WEST SUSSEX COUNTY COUNCIL CONSULTATION

TO:	Arun District Council FAO: Anita Gardner
FROM:	Highways, WSCC
DATE:	19/09/2019
LOCATION:	Wicks Farm, Ford Lane, Ford, Arundel, BN18 0DF
SUBJECT:	F/30/18/PL 2 multispans tunnels, 2 ancillary outbuildings, drainage pond, associated drainage works, external hardstanding for vehicle parking, access and turning. Additional information received.
DATE OF SITE VISIT:	N/A
RECOMMENDATION:	Advice
S106 CONTRIBUTION TOTAL:	£N/A

The LHA has been re-consulted on this proposal following submission of additional information requested by the LHA. This proposal is for 2 multispans tunnels, 2 ancillary outbuildings, drainage pond, associated drainage works, external hardstanding for vehicle parking, access and turning.

PROPOSED ALTERATIONS TO SITE ACCESS TO
FACILITATE TWO WAY HGV MOVEMENTS WITH
AUTOTRACK VEHICLE TRACKING OF A 16.5m HGV

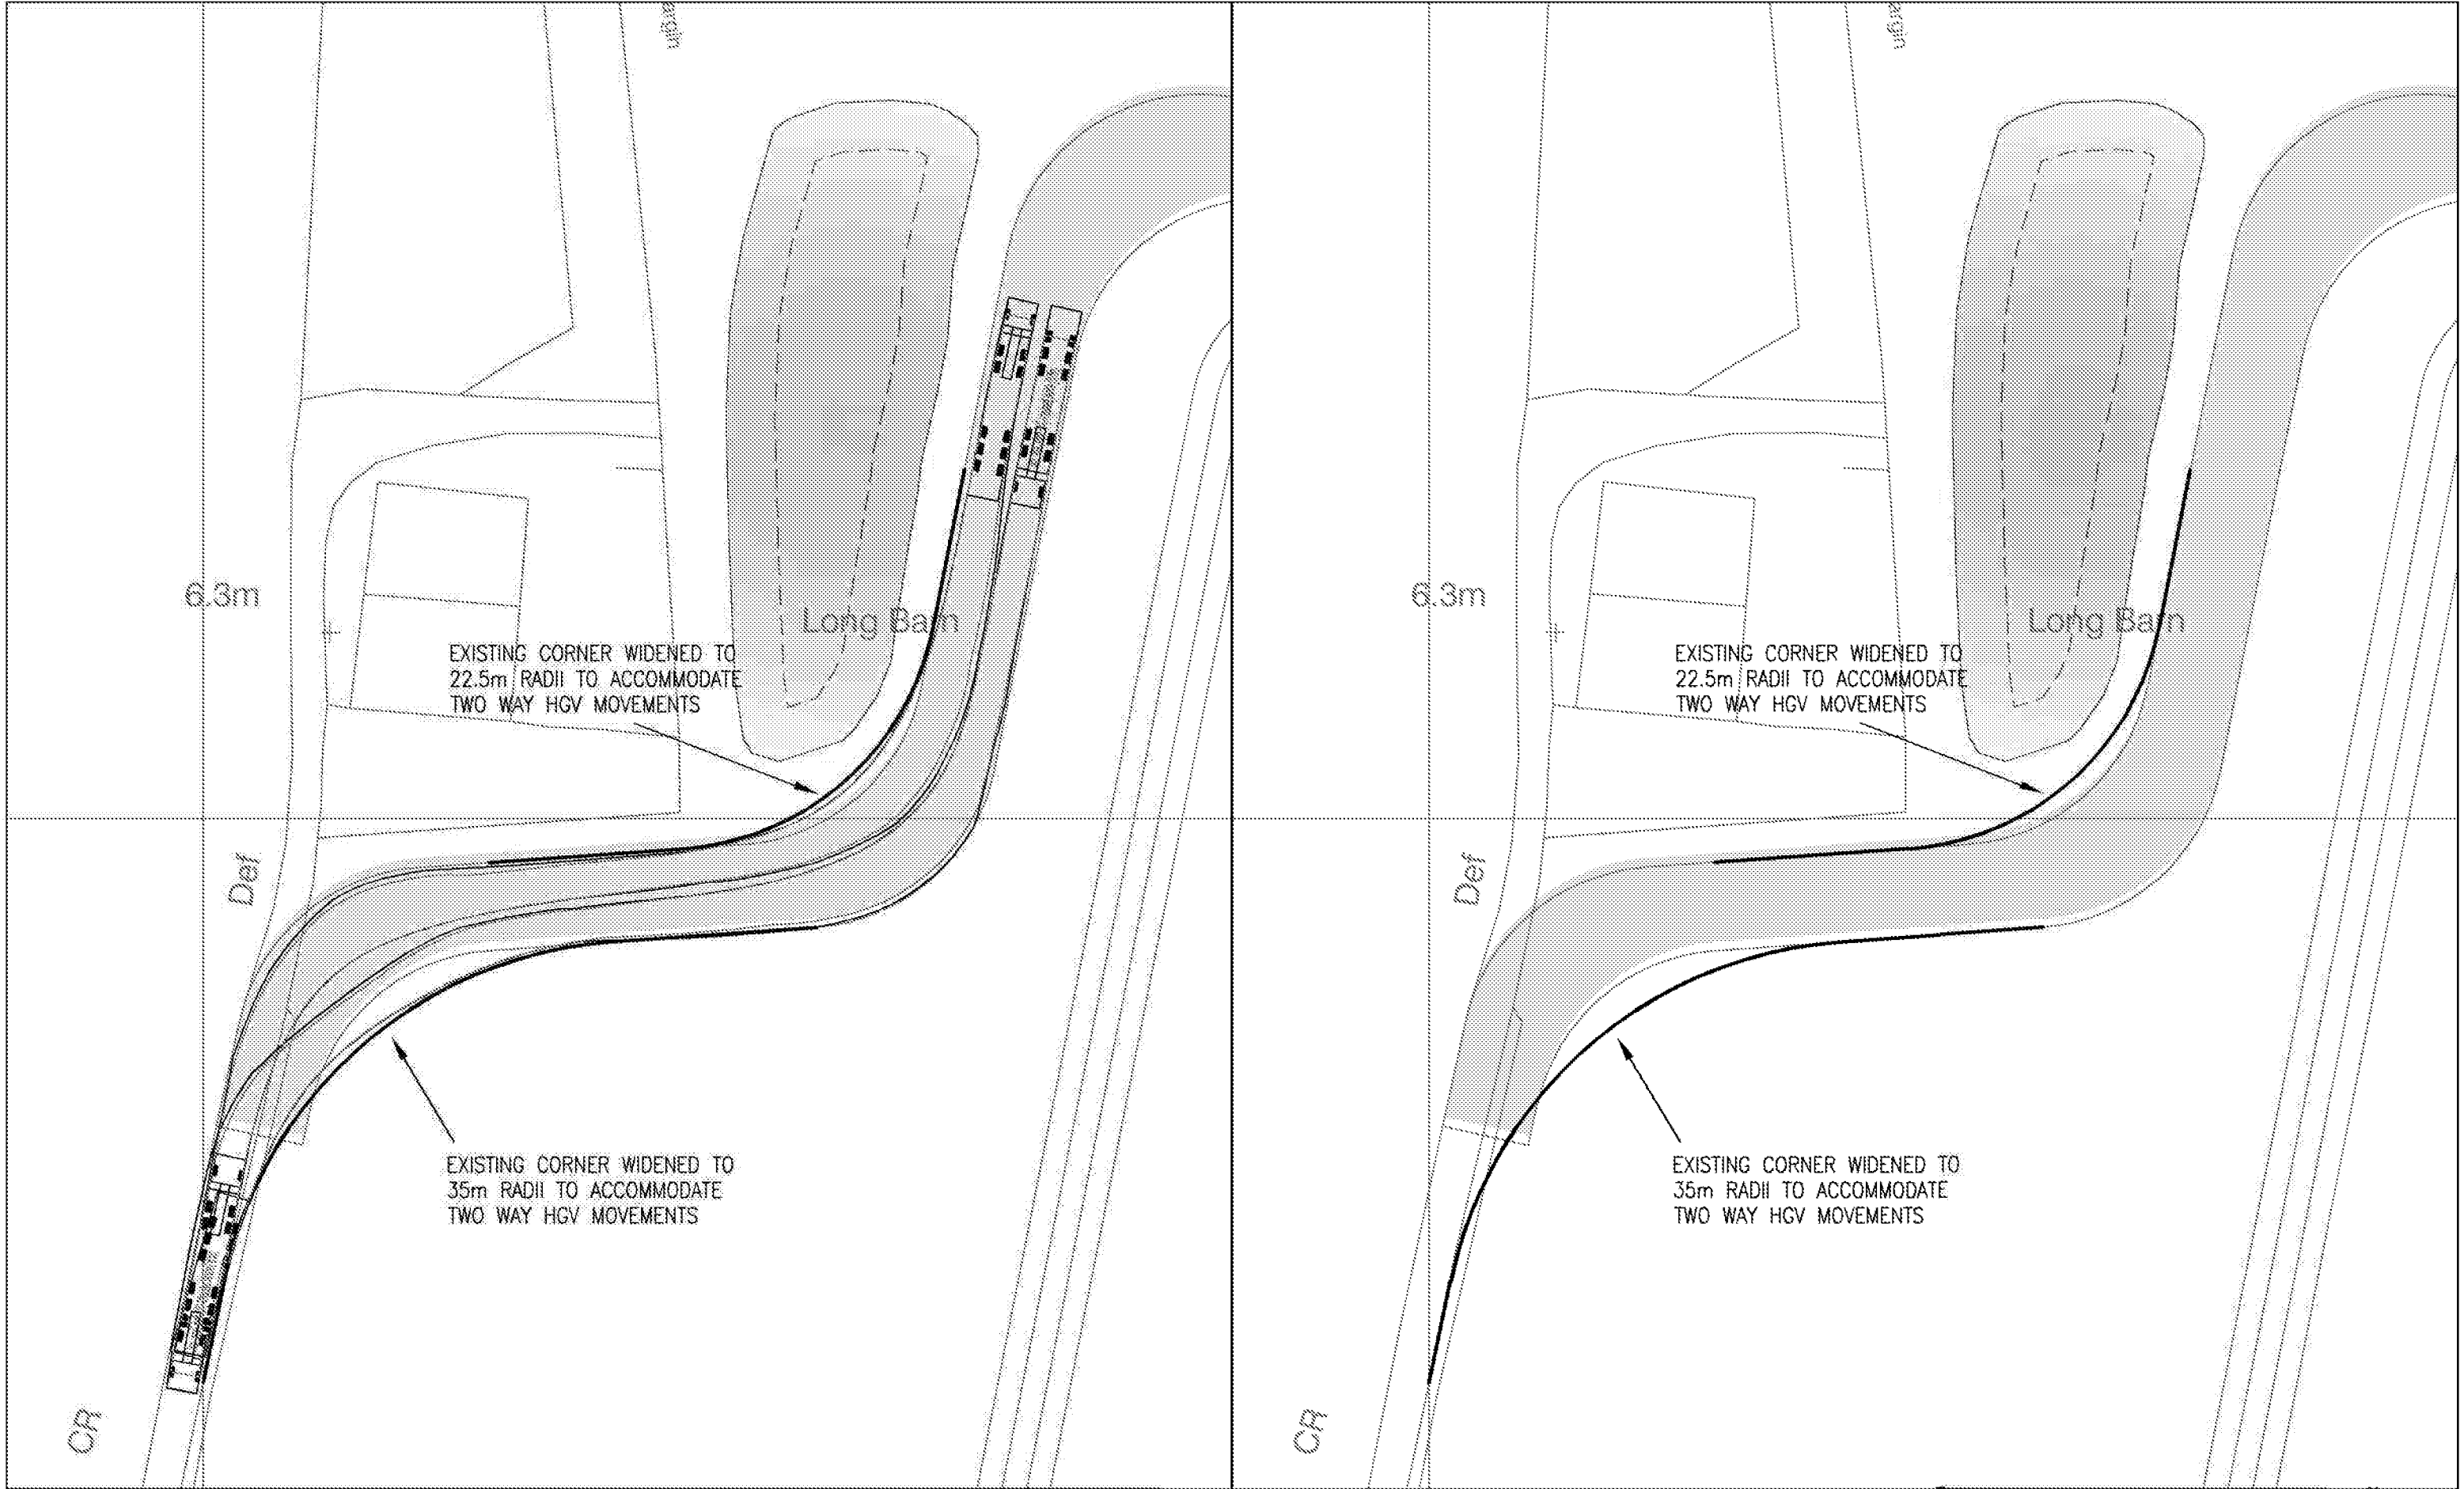
The application has now been supported by a Technical Note prepared by Stuart Michael Associates. Access to the site will be via an existing access track serving the site, which is currently unmade and unsuitable for HGVs. The technical note sets out that the access will be widened to 7.5m for the first 30m, and the first 10m of the access will be a hardened surface and regarded to a maximum gradient of 4% for HGV access. The proposed widening of the track will enable two HGVs to wait and pass within the access, without any obstruction of the public highway. A gate will be provided within the access road, this is positioned far enough into the access road, and will open inwards of the site, such that it will not result in HGVs obstructing the highway whilst the gate is in operation. The applicant has confirmed ownership of the land to either side of the access, enabling the proposed widening the access. The applicant proposes a 10m kerbed radii to the west of the access and a 14m kerbed radii to the east of the access to facilitate the left turn manoeuvre of HGVs exiting the site. The internal access way will be widened in places to facilitate HGV manoeuvrability through the site.

The revised Technical note confirms that all HGVs will be routed east towards Ford Road and the A27 and A259 upon exiting the site. HGVs entering the site will also be routed from the A27 and A259 from Ford Road, i.e. entering from the east of the site. A 'HGVs no right turn ahead' sign will be erected to remind drivers of the routing. The proposed sign should be erected within private land, and not within the public highway. Smaller vehicles such as minibuses and cars will be able to enter and exit the site from any direction and will not be subject to the routing restrictions. The Technical Note confirms that only one HGV will utilise the access at any one time, to ensure that exiting HGV drivers can position the vehicle within the access to safely undertake a left turn manoeuvre.

Revised swept path tracking has been provided demonstrating that HGVs can safely enter the site from the east, and exit to the east utilising the proposed widened access. The revised tracking indicates that a left turn manoeuvre is achievable without the requirement for HGVs to cross the centre line of the carriageway, or utilise third party land.

No part of the development shall be first occupied until such time as the vehicular access serving the development has been constructed in accordance with the details shown on the drawing titled 'Proposed Access Arrangements with Autotrack Vehicle Tracking of a 16.5m HGV' and numbered 6352.001 Rev A.

LONGITUDINAL PROFILE BETWEEN DRIVER EXITING PROPOSED SITE ACCESS AND ONCOMING DRIVER TO THE WEST OF THE SITE ACCESS
(FROM A TO B, REFERENCE PLAN ABOVE) ALONG THE 125m INTERVISIBILITY ENVELOPE

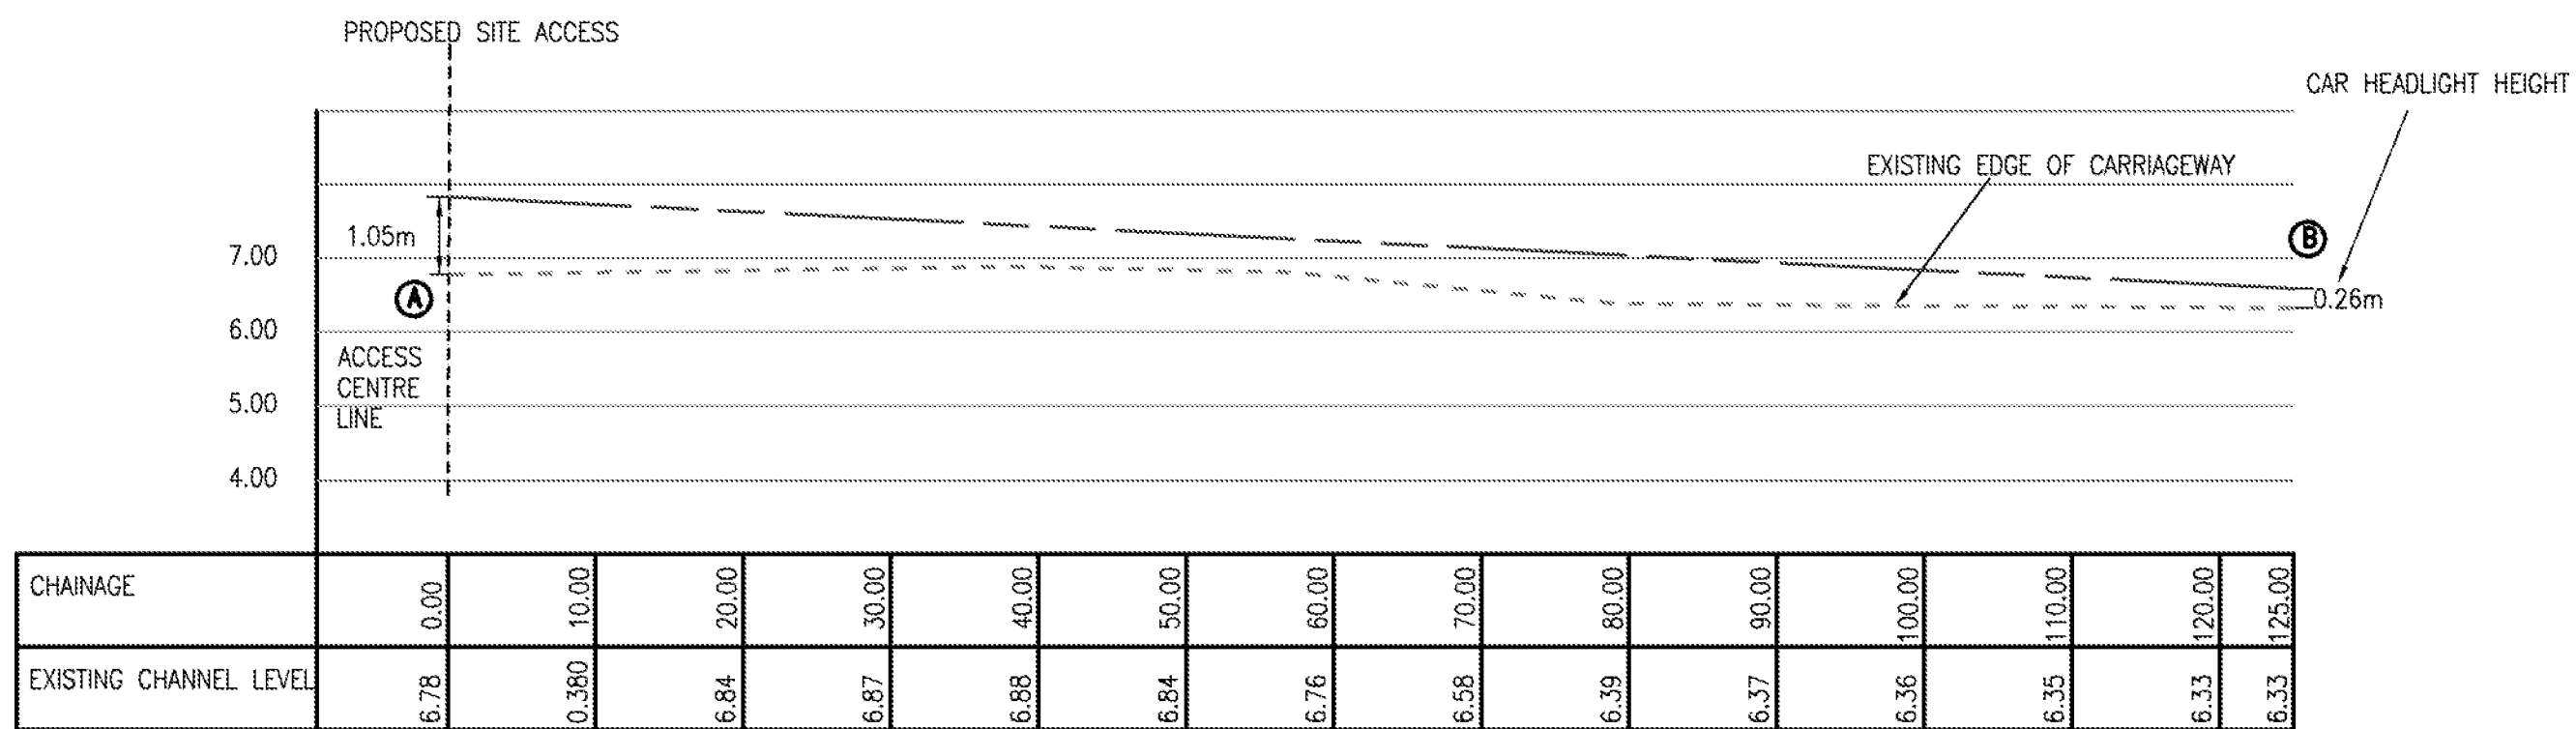
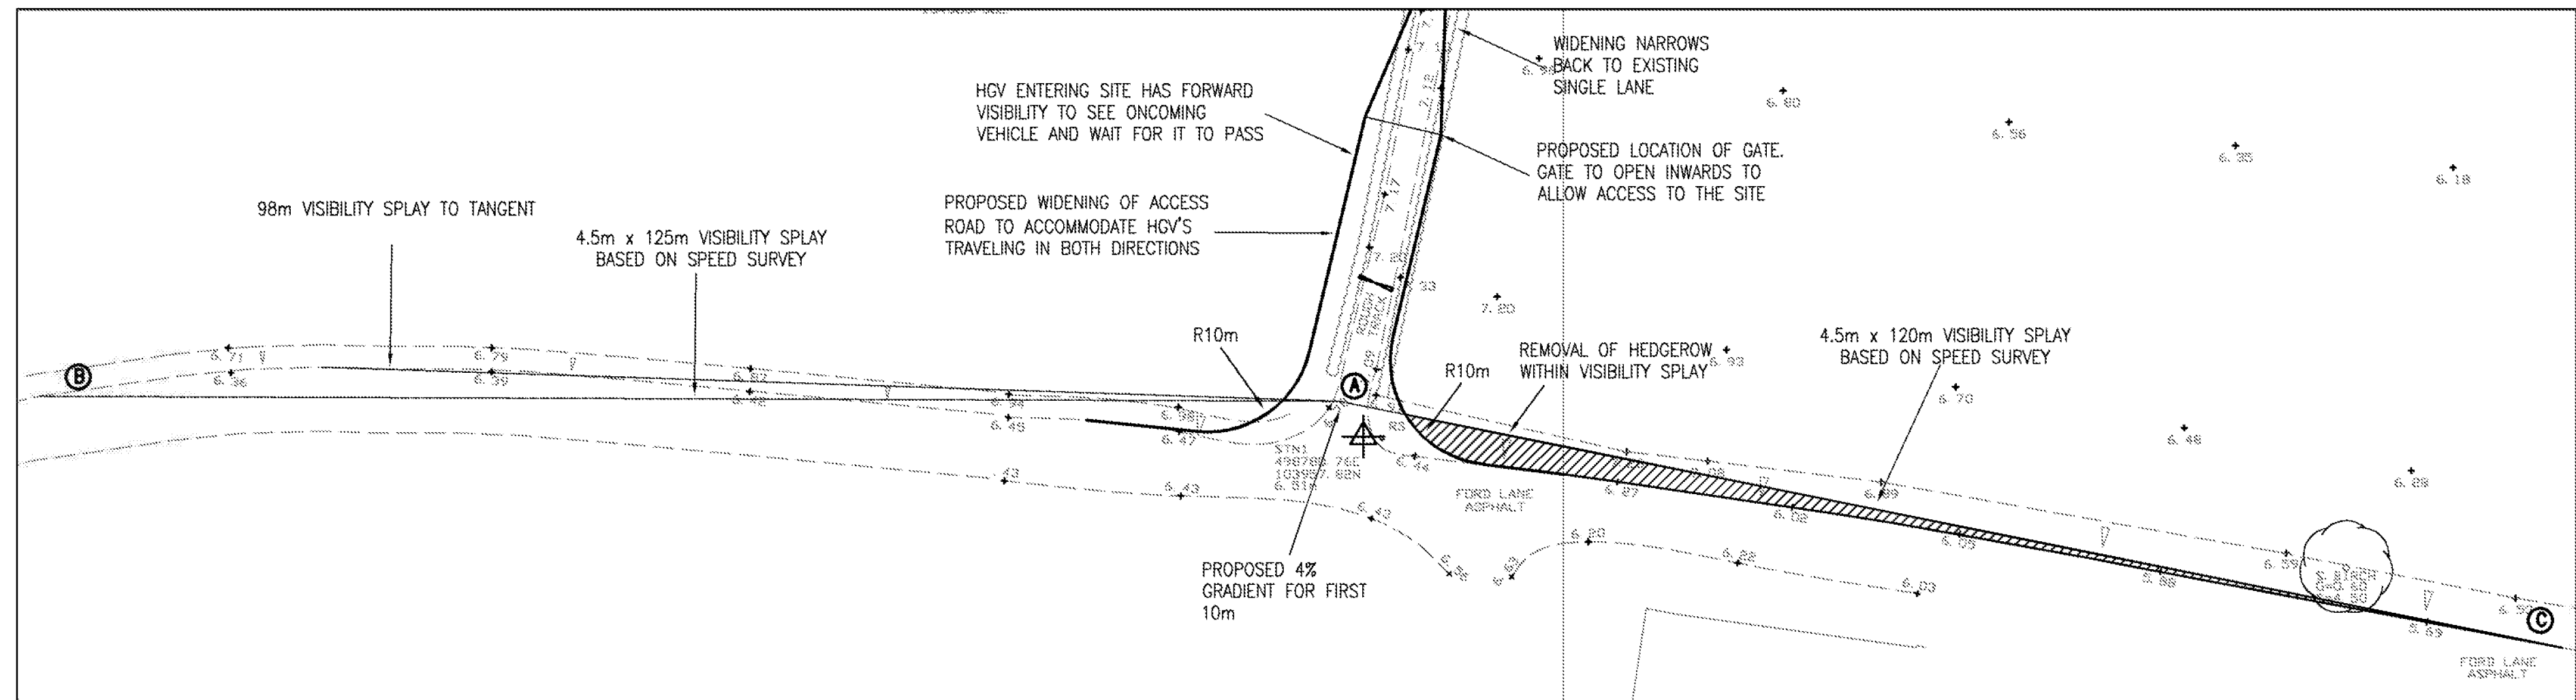
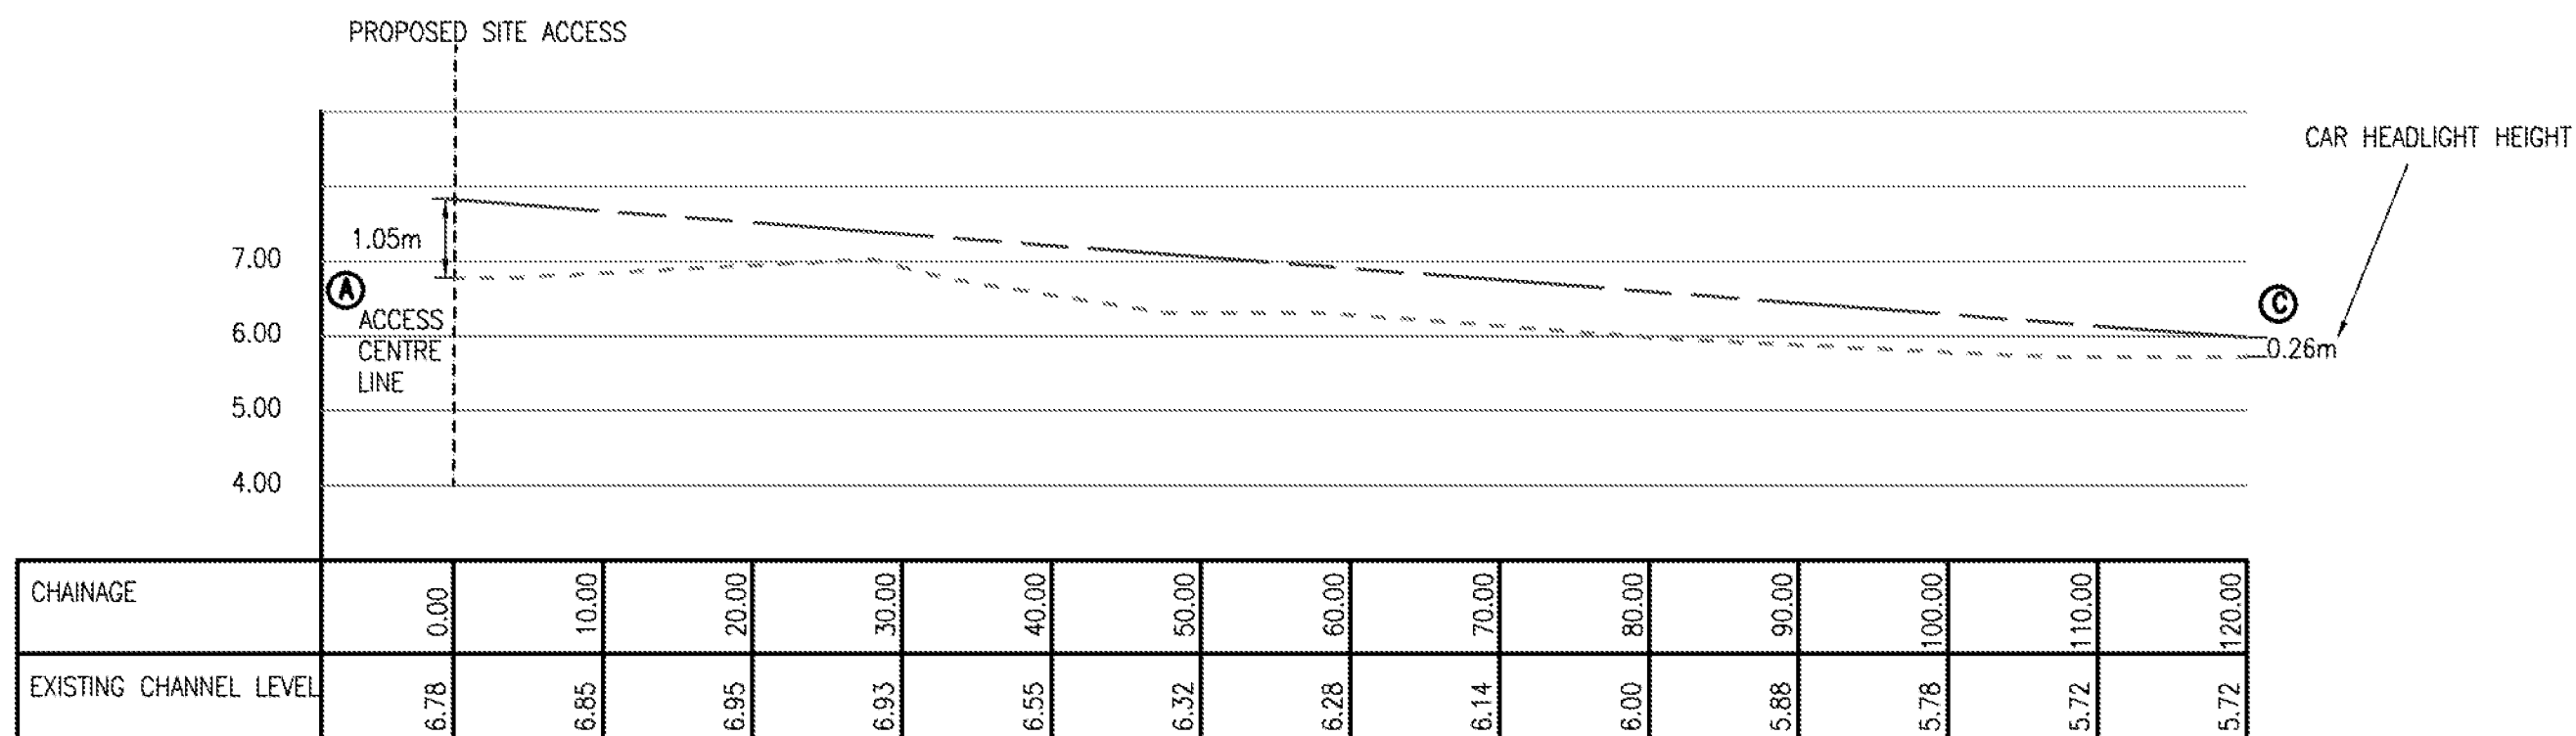
The applicant has undertaken a seven day speed survey to determine 85th percentile speeds along Ford Lane in this location. Ford Lane is subject to a speed limit of 60mph, reducing to 40mph approximately 300m to the east of the site. The speed survey indicated 85th percentile speeds of 47mph eastbound and 48mph westbound. This has been adjusted for wet weather, resulting in wet weather 85th percentile speeds of 44.5mph eastbound and 45.5mph westbound. The LHA accept a reduction in achievable visibility splays in accordance with wet weather 85th percentile speeds and would anticipate splays of 4.5m x 120m to the east of the access and 4.5m x 125m to the west. The applicant has provided a plan demonstrating that these splays are achievable at the proposed widened access, utilising both publicly maintained highway and the applicant's own land. The applicant proposes to remove hedgerow to the east of the access which falls within the visibility splay. There should be no obstructions over a height of 0.6m within these splays and the applicant has demonstrated that the envelope of vertical visibility is sufficient at the proposed widened access at a drivers' eye height of 1.05m and that the bank to the west of the access does not obstruct visibility for drivers.

No part of the development shall be first occupied until visibility splays of 4.5 metres by 125m to the west and 4.5m by 120m to the east have been provided at the proposed site vehicular access onto Ford Lane in accordance with the approved planning drawings. Once provided the splays shall thereafter be maintained and kept free of all obstructions over a height of 0.6 metre above adjoining carriageway level or as otherwise agreed.
